**From:** Chris Moore   
**Sent:** 27 April 2025 23:16  
**To:** Iqraa Malik  
**Subject:** FW: Request for further information AW/101/25/HH  
**Attachments:** AW\_101\_25\_HH202504241055378226.pdf; Prop Rear Side Elevations 3 Loft.pdf

PROPOSED ELEVATIONS

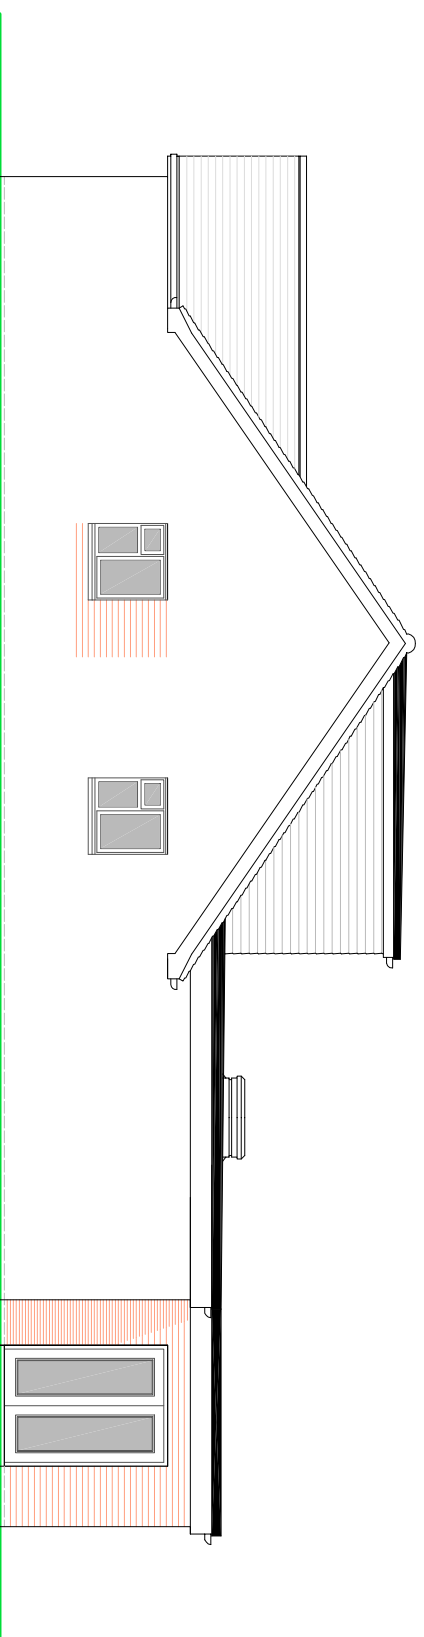
I attach a copy of the correct Proposed Rear/Side Elevations as requested - the rear facing window in the store is now omitted. Please delete the 'Proposed Elevations' file – this was mistakenly submitted.
